**Our ref:** WX/2022/136152/03-L01  
**Your ref:** TR010025  
**Date:** 02 August 2022

**A303 STONEHENGE (AMESBURY TO BERWICK DOWN) DEVELOPMENT  
CONSENT ORDER APPLICATION. REQUEST BY DEPARTMENT FOR  
TRANSPORT FOR COMMENTS ON THE INFORMATION PROVIDED AS PART OF  
THE APPLICANT'S RESPONSE TO SECRETARY OF STATE LETTER DATED 20  
JUNE 2022.**

PROPOSED BORED TUNNEL - (WORK No. 1F)

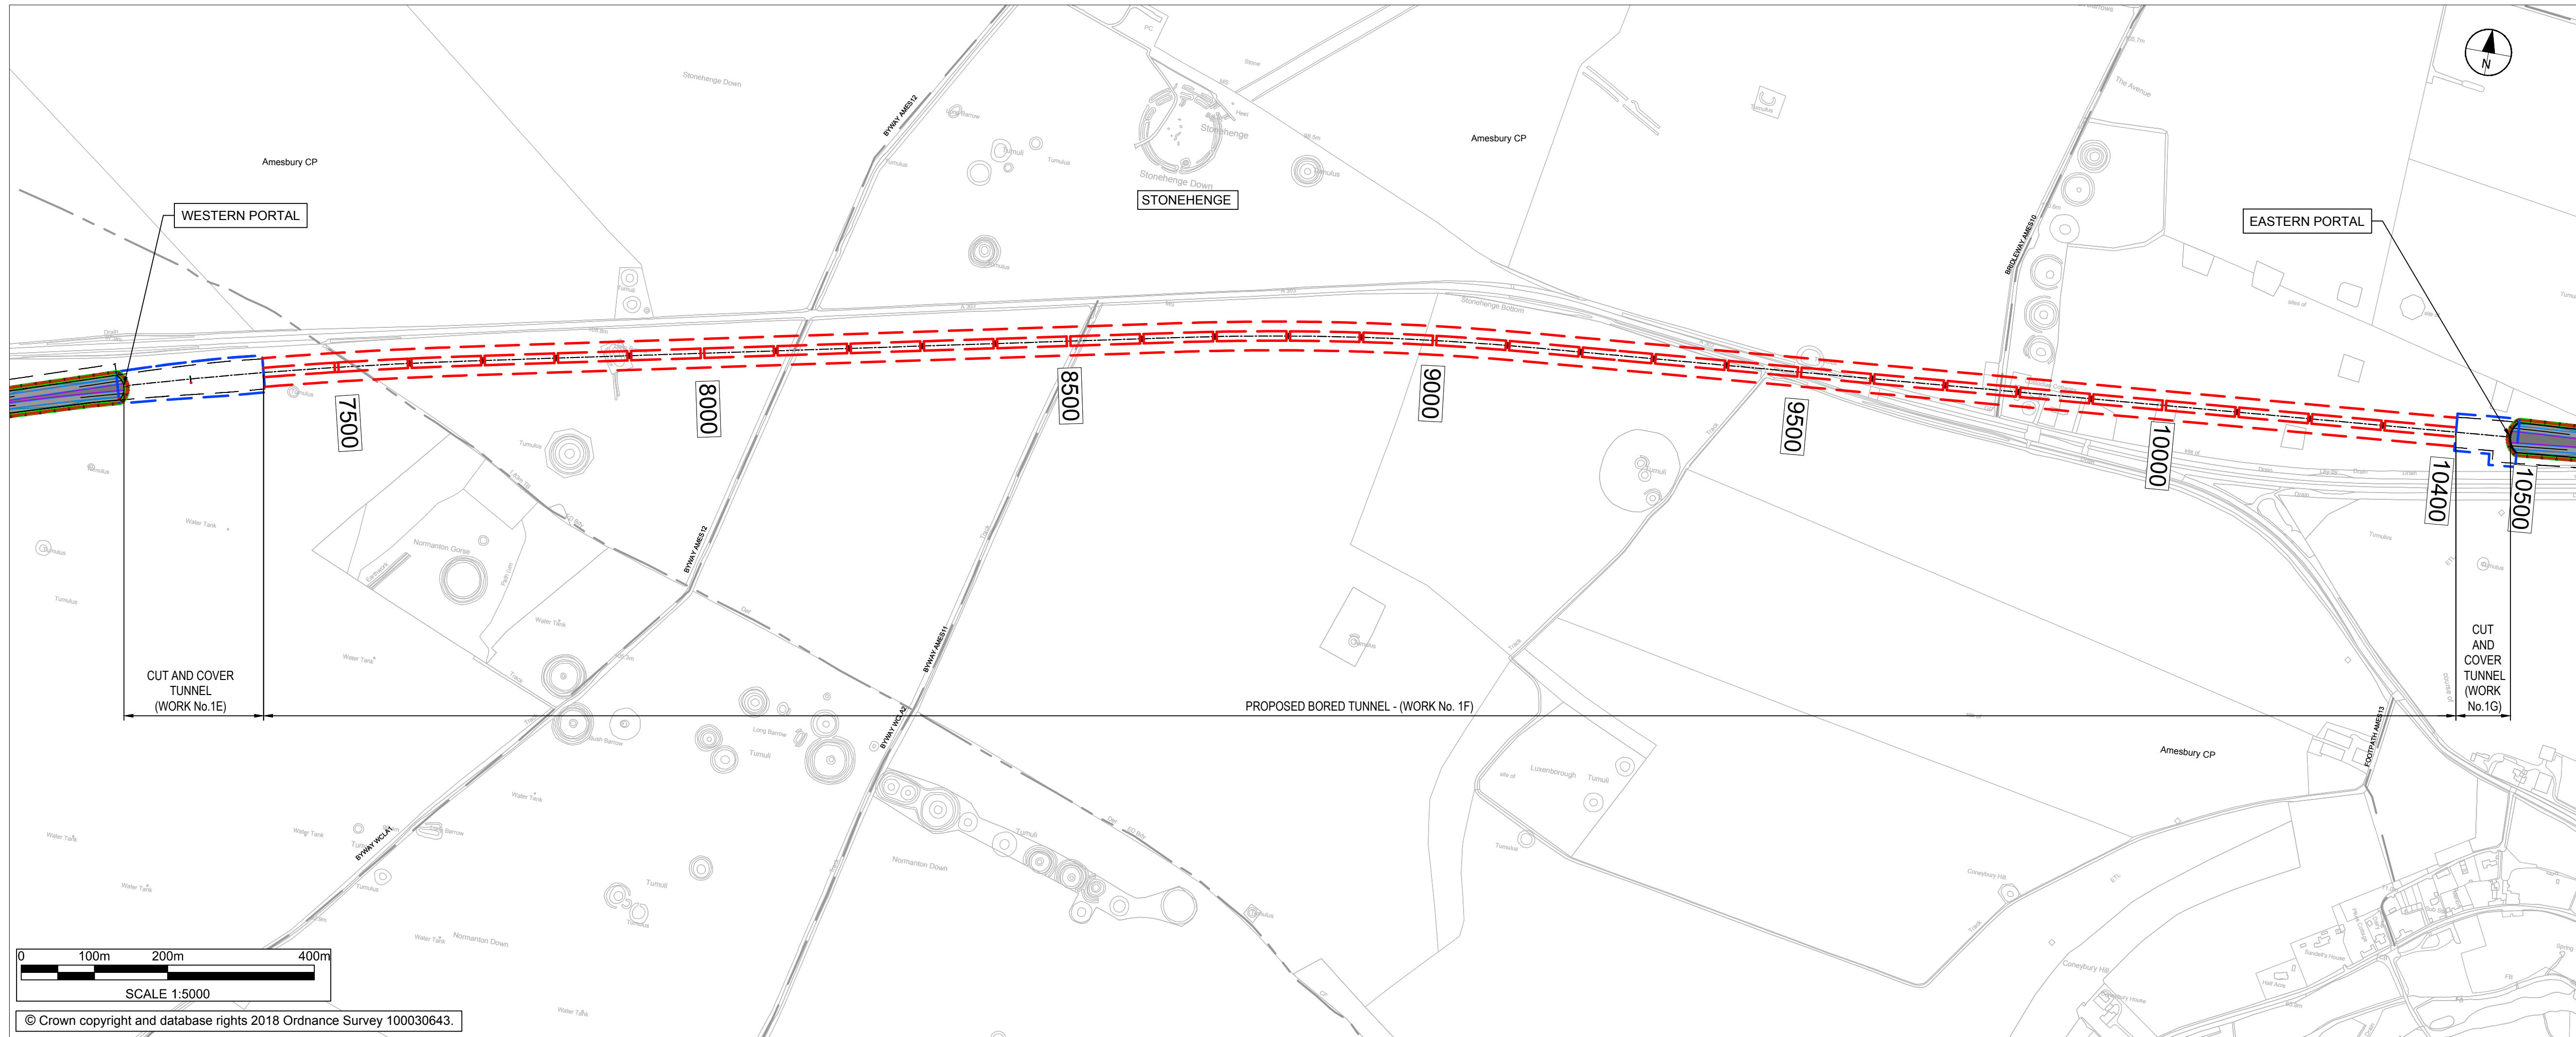
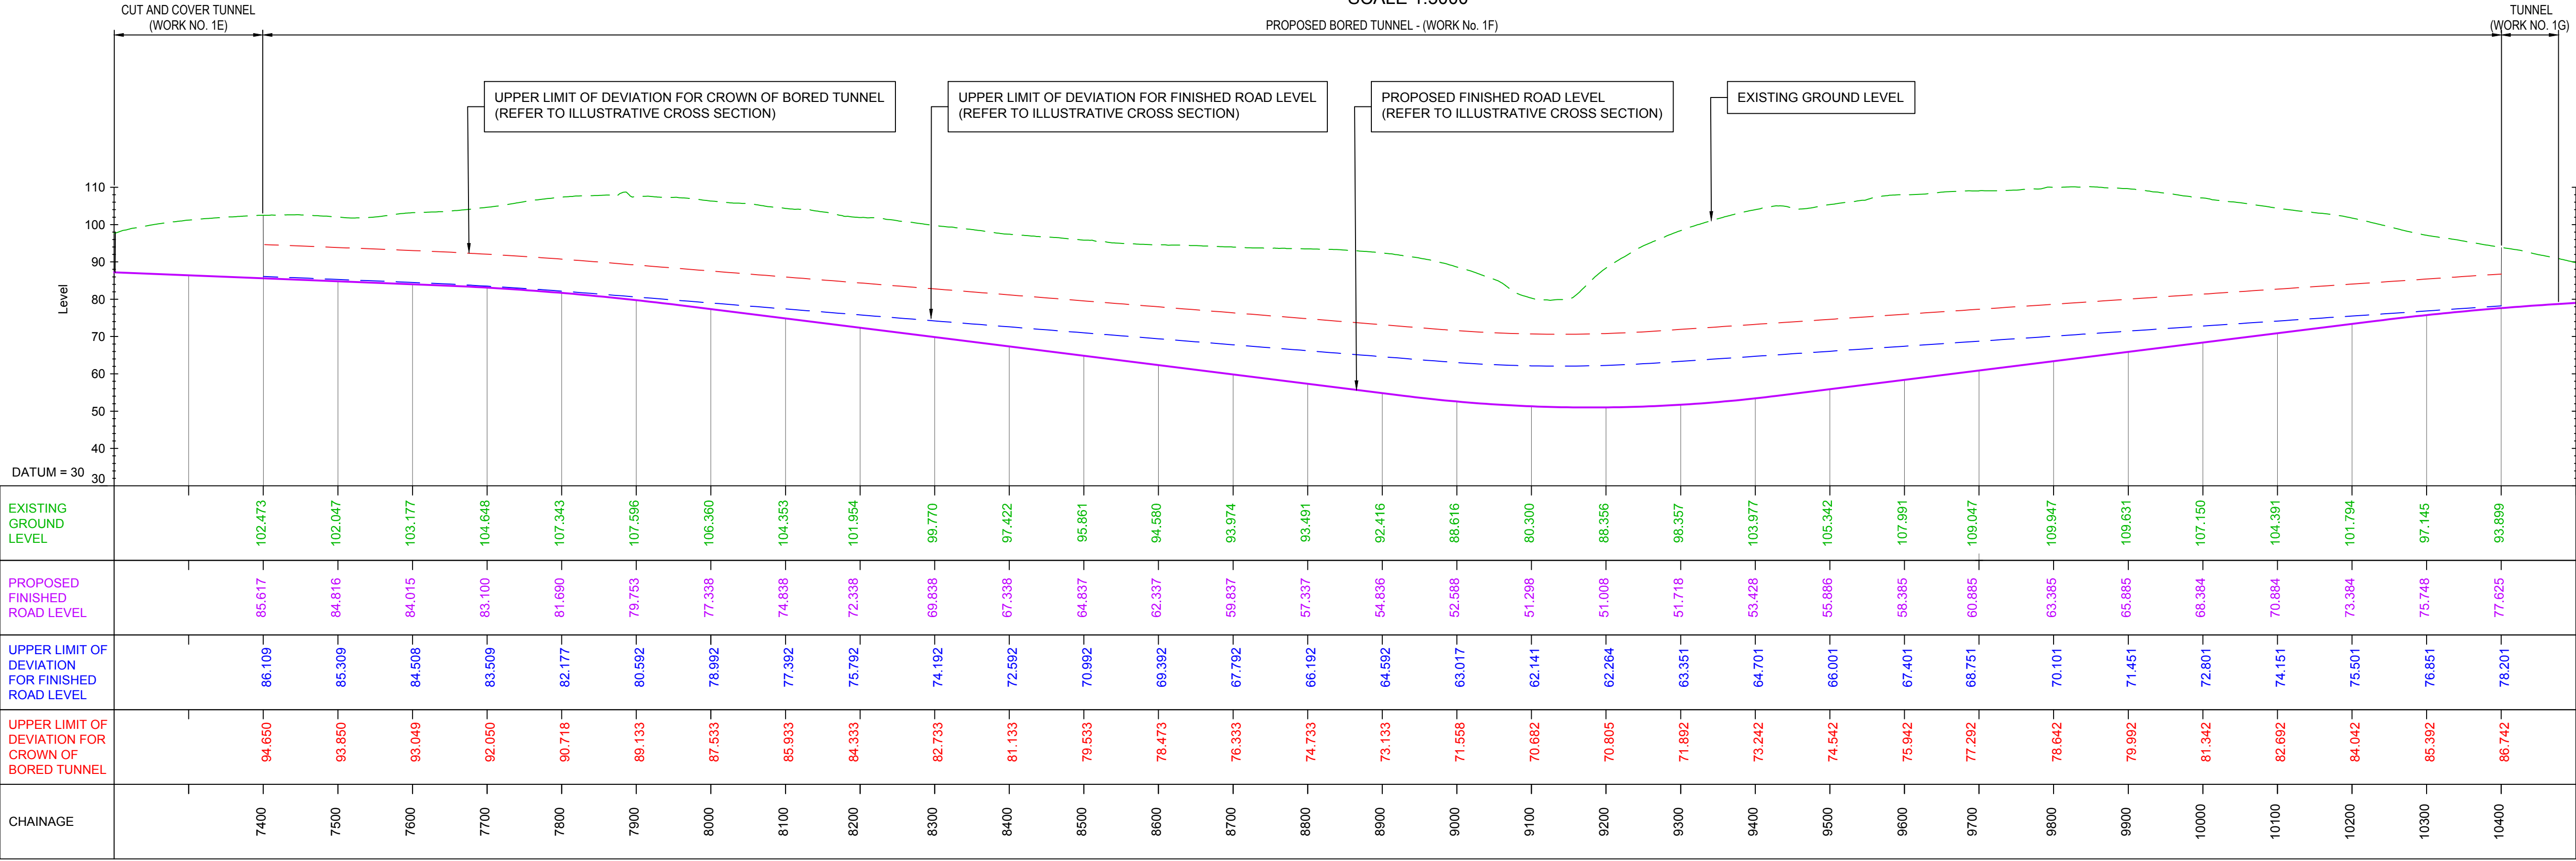
The relationship between the vertical alignment of the extended tunnel alternatives and the groundwater level have not been presented and there has been no modelling and assessment of the extent and magnitude of impacts from a c.40% longer tunnel. This information is required to determine the likely impacts from the alternatives and whether they are acceptable or can be adequately mitigated.

Paragraph 4.8.6 of both documents states that the groundwater modelling undertaken so far supports the conclusion that there will be no significant effects at the River Till from an extension to the tunnel. Paragraphs 5.2.36 and 5.2.35 relating to the Bored Tunnel Extension and Cut and Cover Tunnel Extension Environmental Appraisals respectively state that impacts on groundwater flow will be no more significant than the DCO Scheme. We disagree strongly with these statements since the impacts of an extended tunnel have not been modelled and the length of tunnel is significantly longer and comes closer to the River Till. The groundwater modelling conducted to date was set up to represent the DCO Scheme design and therefore cannot be considered to demonstrate the effects of a different design. We recommend that the modelling is repeated to demonstrate the extent and magnitude of impacts from the alternative designs and inform any decision to alter the proposed scheme design.

Despite identifying groundwater abstractions as potential receptors, the Road Drainage and the Water Environment sections in chapters 4 and 5 make no reference to potential changes to groundwater levels at abstraction points that may be caused by an extended tunnel. The extension would mean the tunnel is closer to some abstractions and could potentially bring them within the extent of groundwater level changes. The potential for derogation to existing abstractions should be assessed and mitigation proposed where necessary.
